from
**Southern
Water**

Your ref
AB/113/21/DOC

Proposal: Approval of details reserved by condition imposed under AB/39/18/PL relating to conditions 3-Construction Management Plan, 4-surface water drainage & 5-foul & surface water sewerage disposal.

Site: AB/113/21/DOC: - 30 Ellis Close, Arundel, BN18 9LG.

Drawing Title **Topographical Survey, Proposed Levels & Drainage GA**

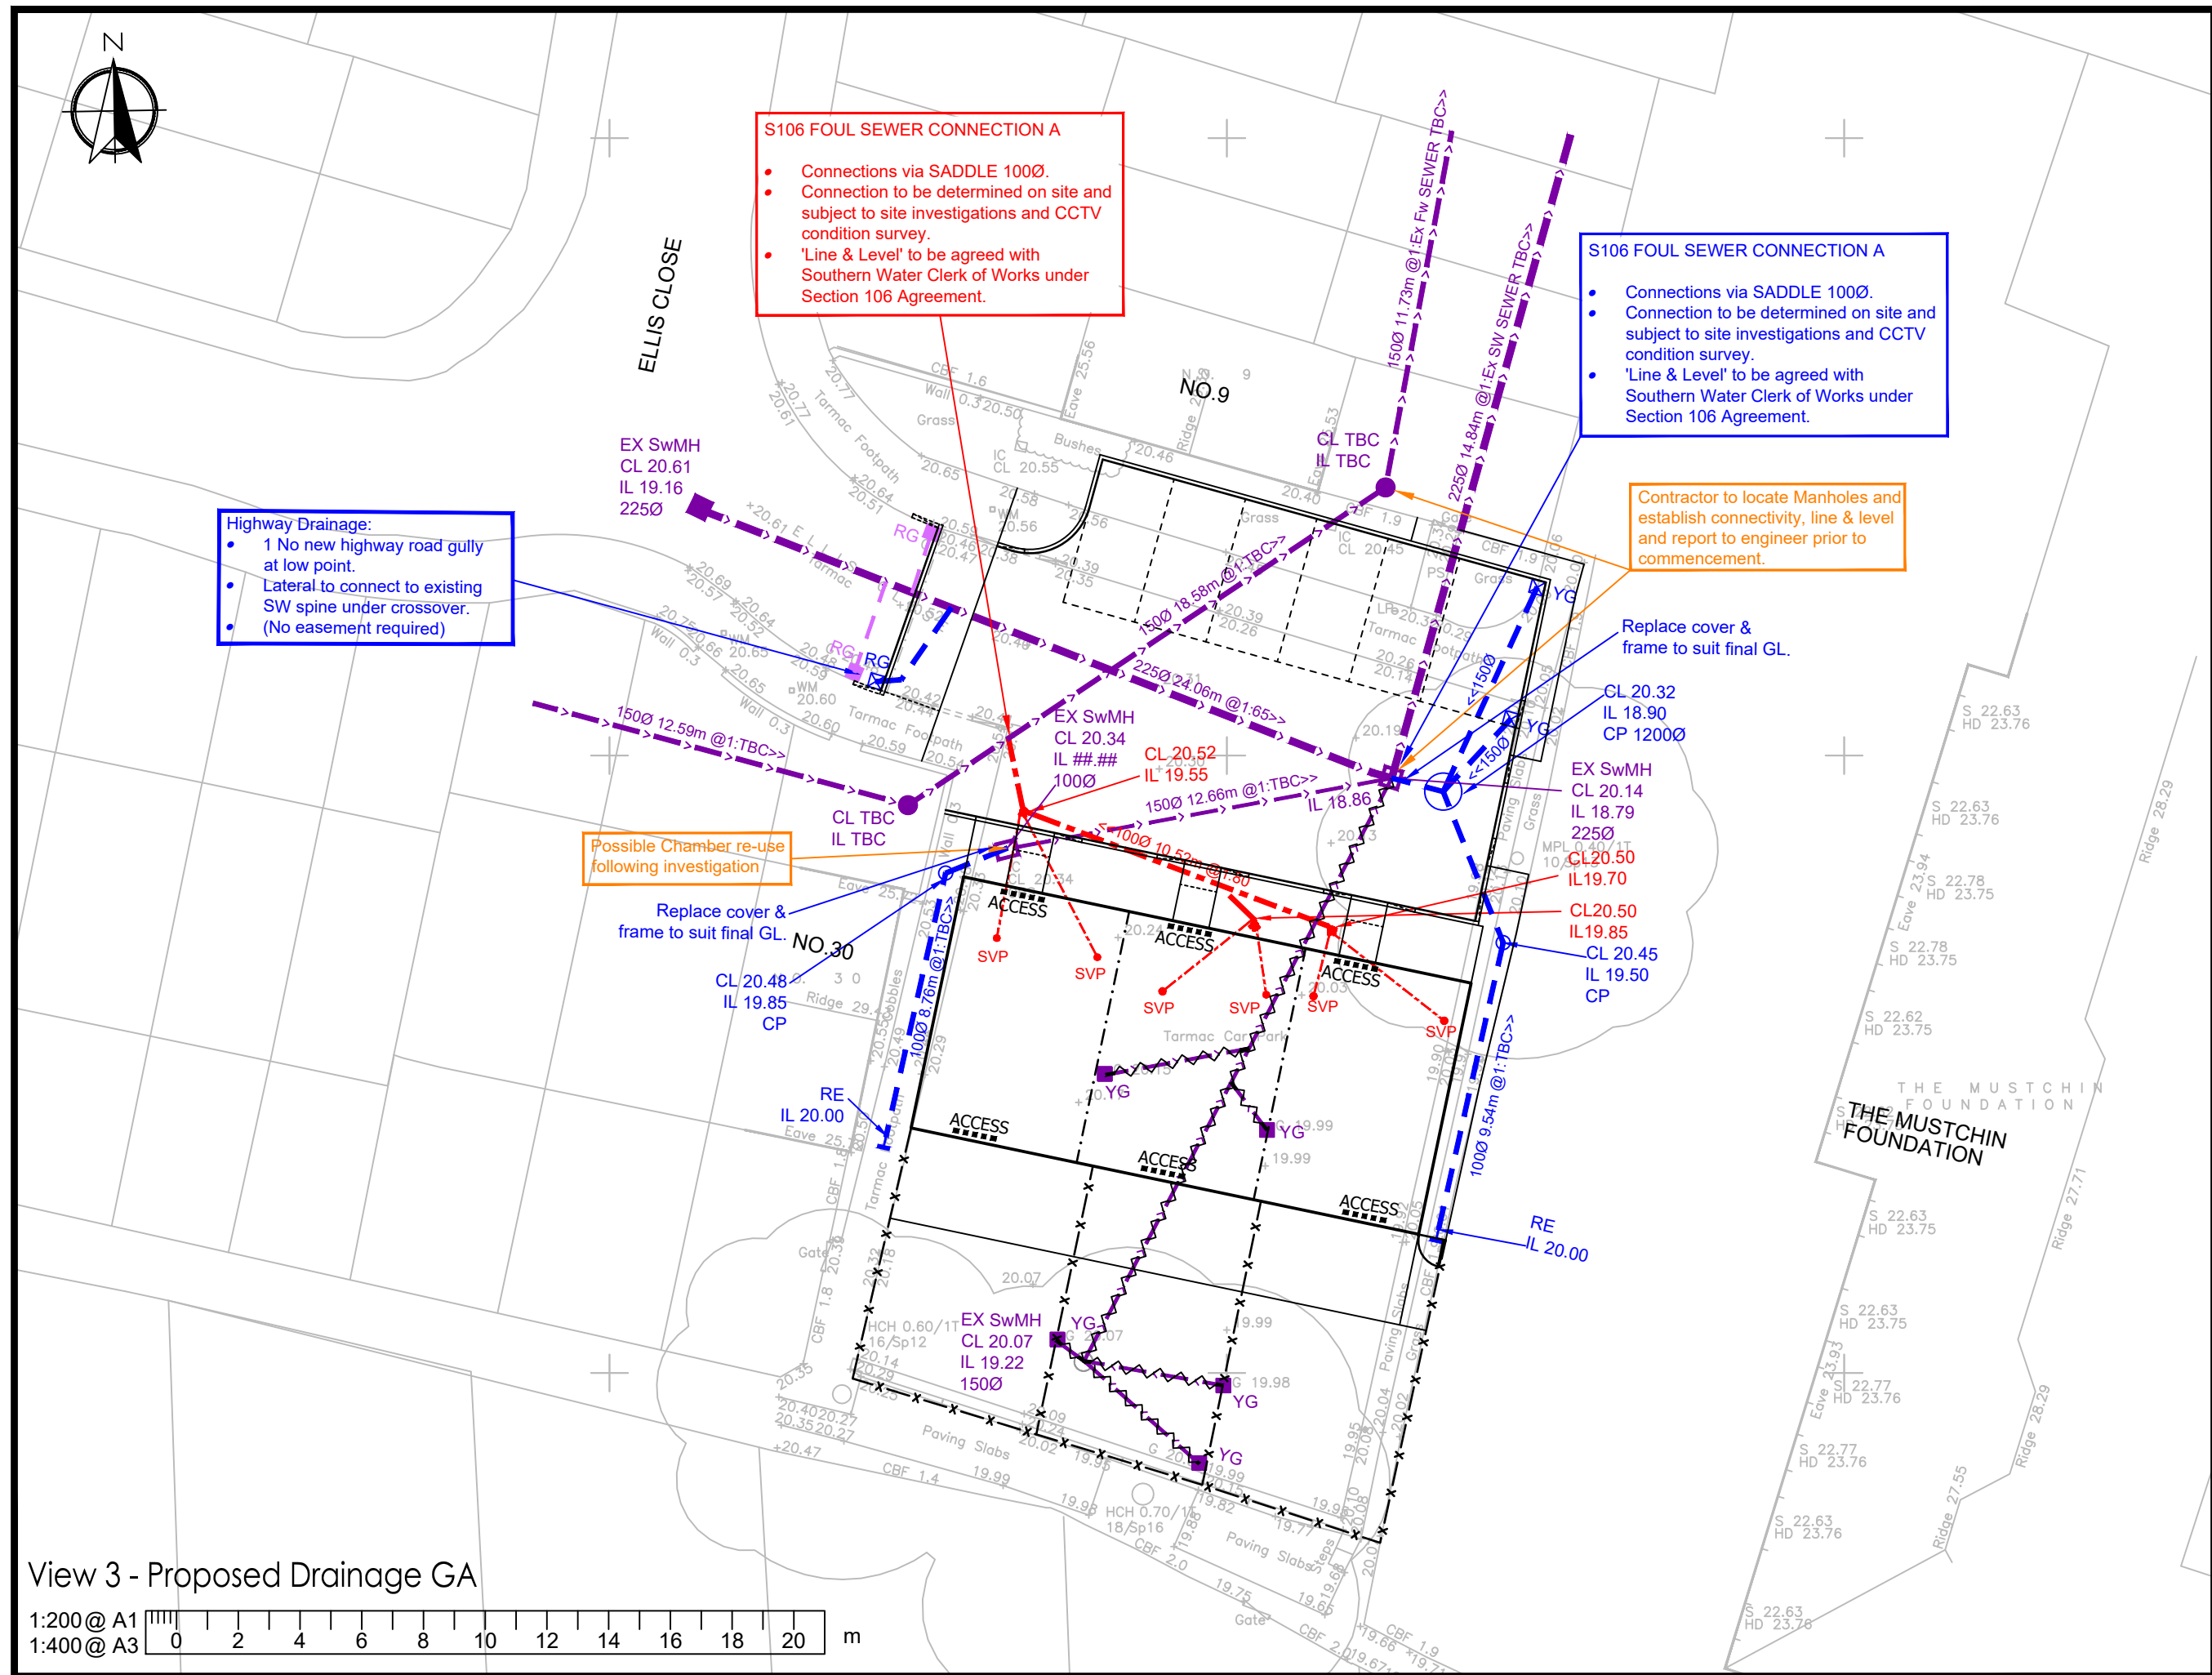
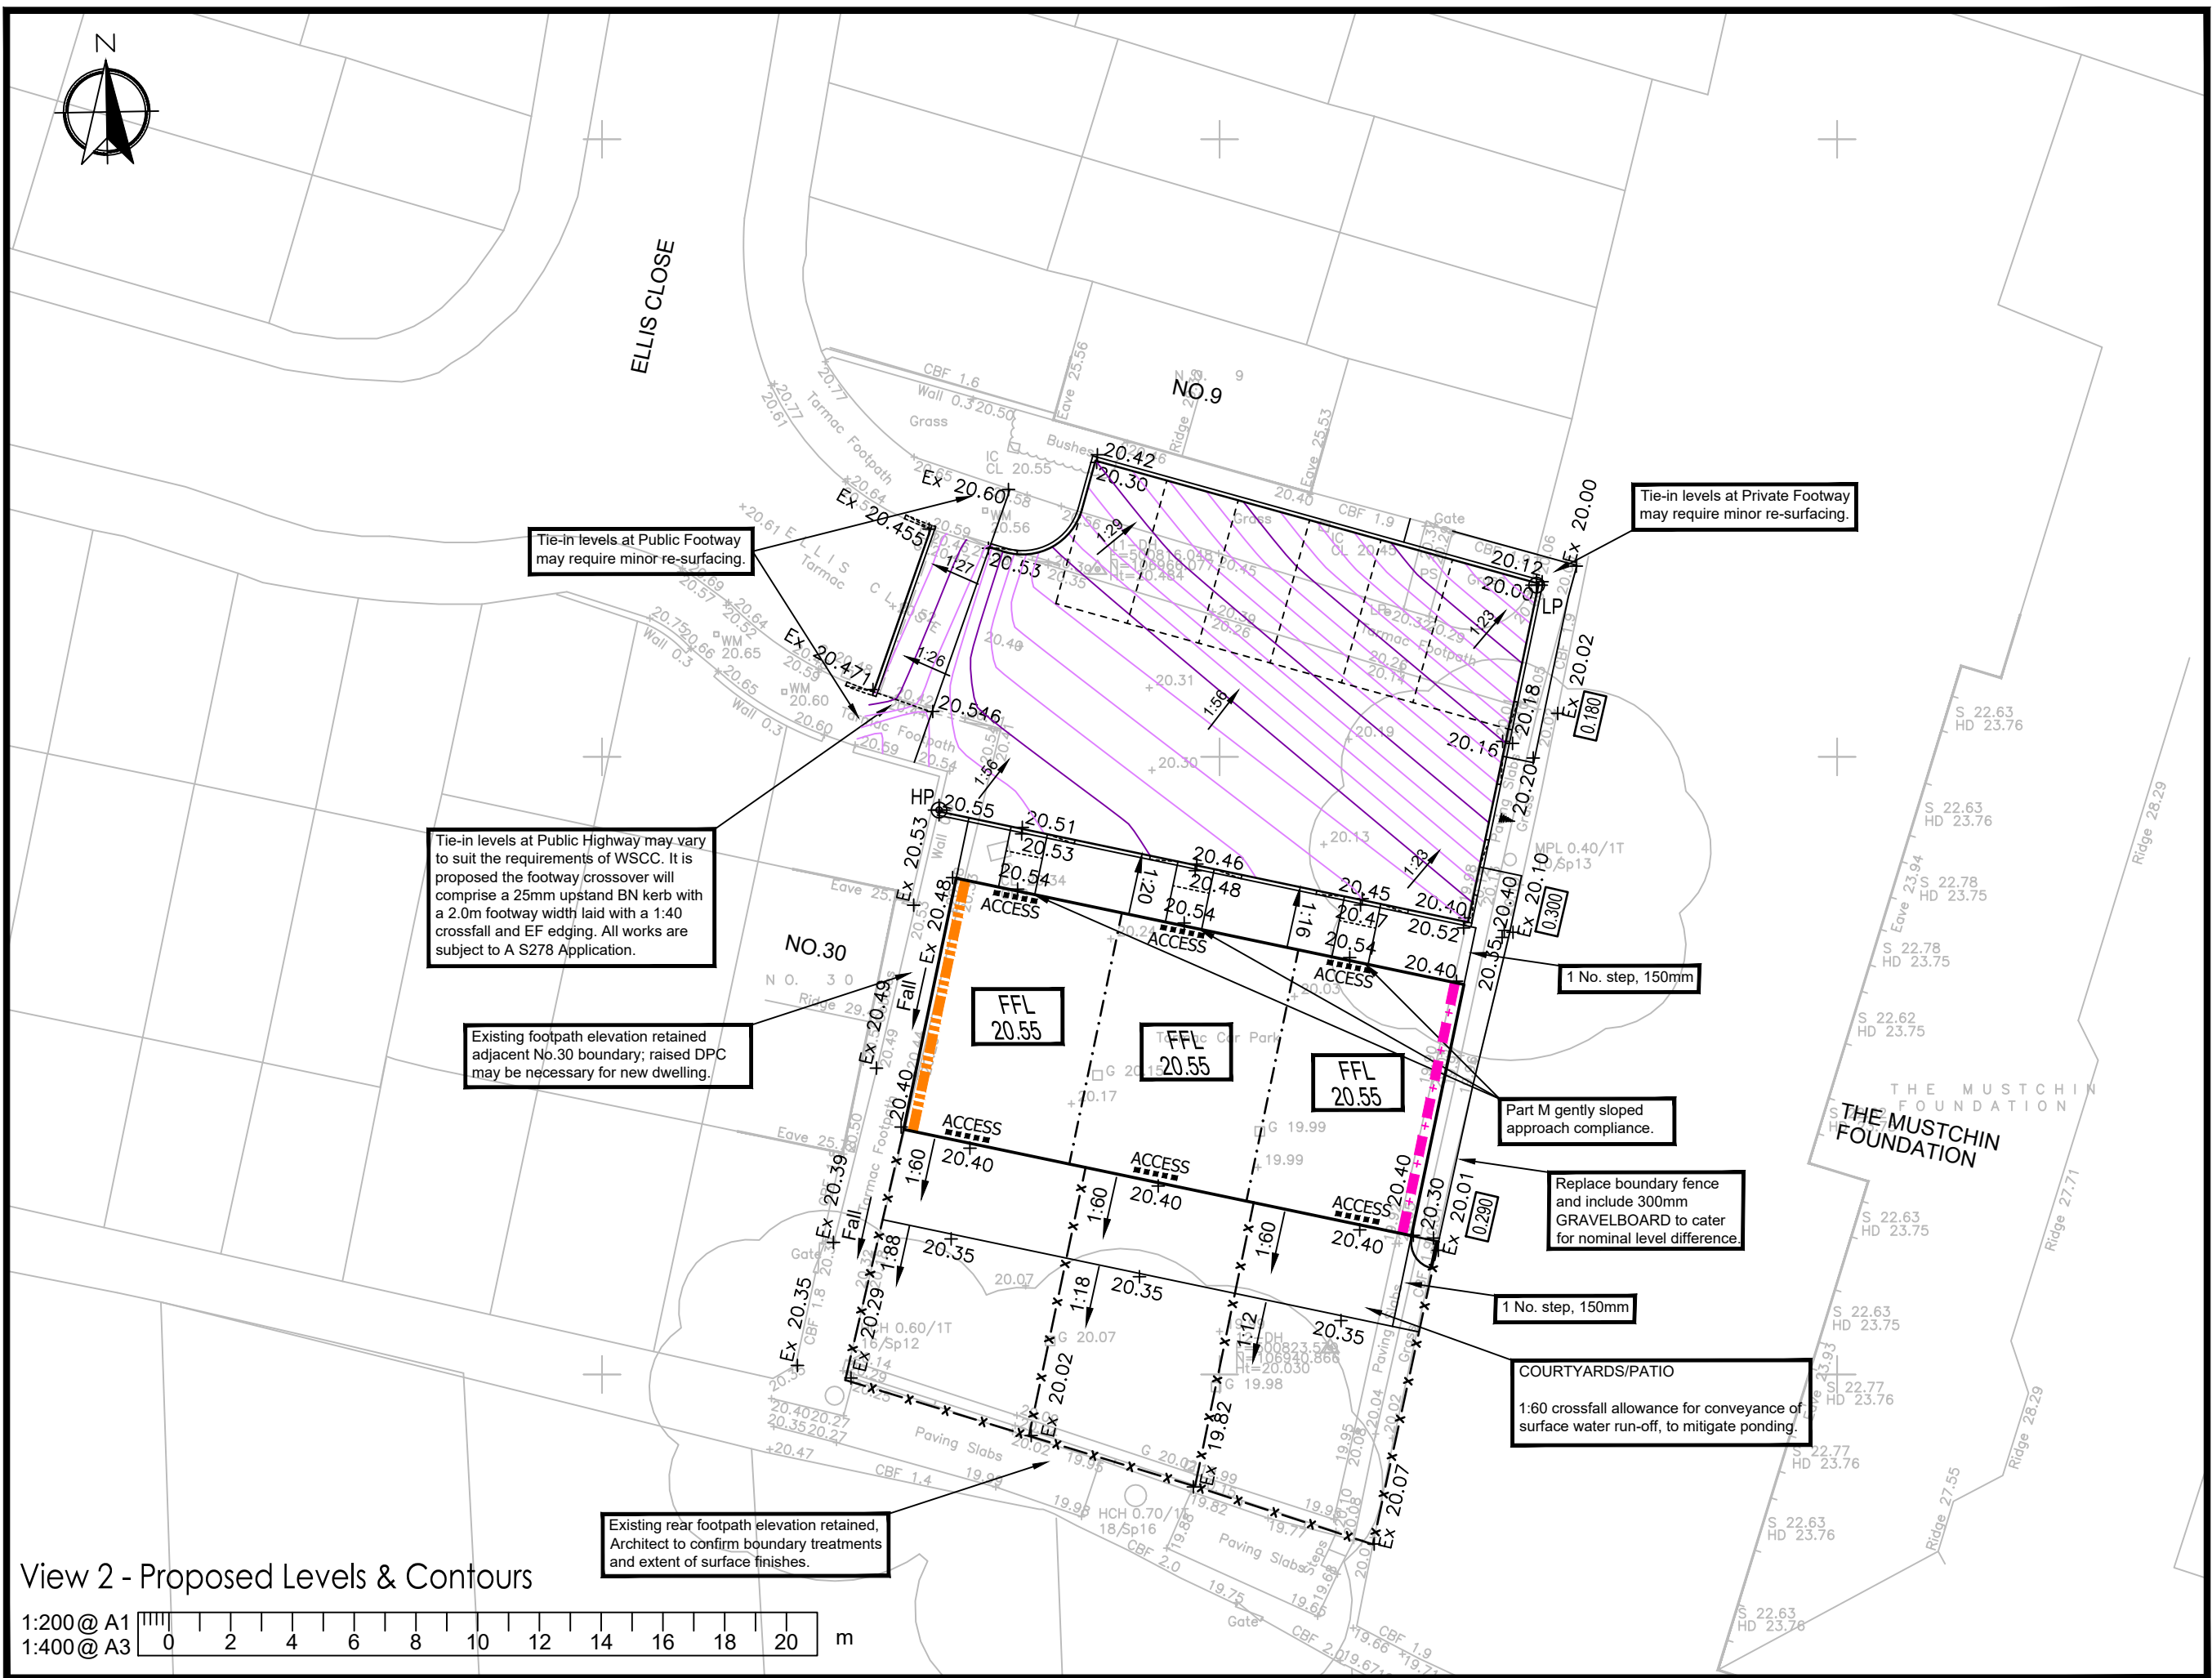
Southern Water cannot recommend discharge of conditions 05 and 04 related to foul and surface water drainage. No new development/building works will be permitted to be constructed over or within 3.0 metres of the existing sewer. The public sewer on the site needs to be diverted to maintain required standoff distance. Any public sewer diversion proposals shall be approved by Southern Water under Section 185 of the Water Industry Act. An application should be made using Southern Water's Get Connected Service at:

The drainage information submitted indicates that the proposed surface water flows from the building are reduced from the existing contributing flows. This discharge can be permitted, if proven to be connected and it is ensured that there is no overall increase in flows into the surface water system. The applicant will be required to provide a CCTV survey showing the existing connection points, pipe sizes, gradients and calculations confirming the proposed flow will be no greater than the existing contributing flows.
